**SUBJECT: ERES2407-0055
ELECTRICAL RESIDENTIAL**

Here are the results of all Inspections located at **20 BARN LOFT CT:**

Inspection Type: FINAL**
Scheduled Date/Time: 9/5/2024
Completed Date/Time: 9/5/2024
Inspector: Justin Ryan McLeod
Result: DISAPPROVED
Remarks:
Notes: See attachment pictures

SINGLE LINE DIAGRAM

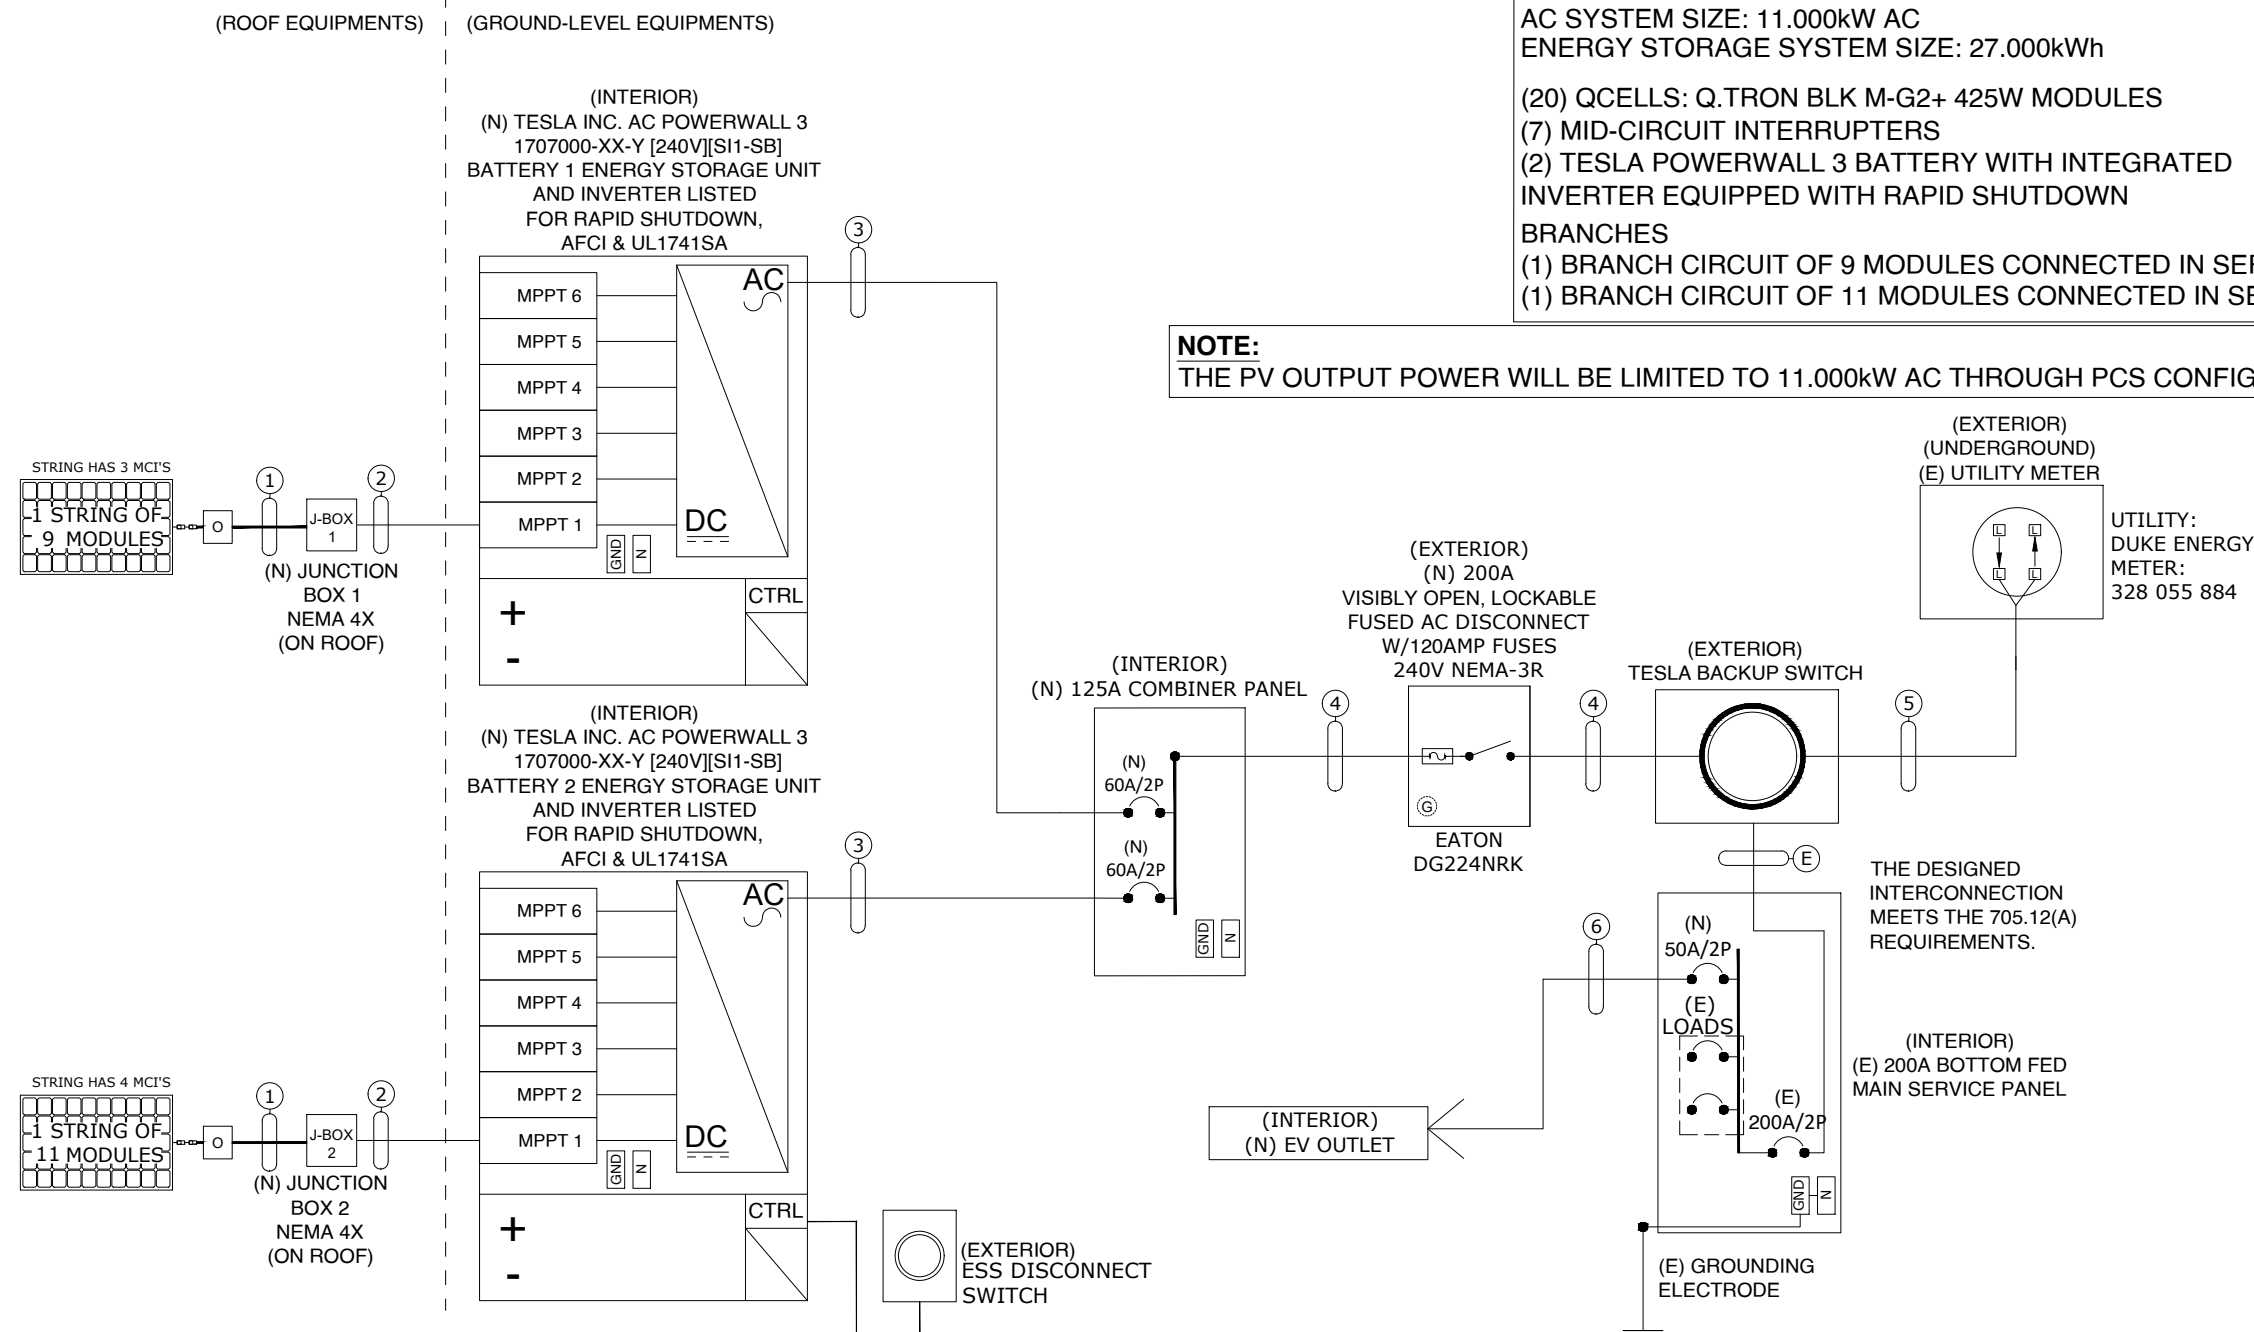
Number 6 installed coming out of combiner panel, plan states #4 wire. Outside fuses should be 120amp there are 125 installed

Inspection Type: FINAL**
Scheduled Date/Time: 9/12/2024
Completed Date/Time: 9/12/2024
Inspector: Justin Ryan McLeod
Result: APPROVED
Remarks:
Notes: Engineer revised plans to match install.
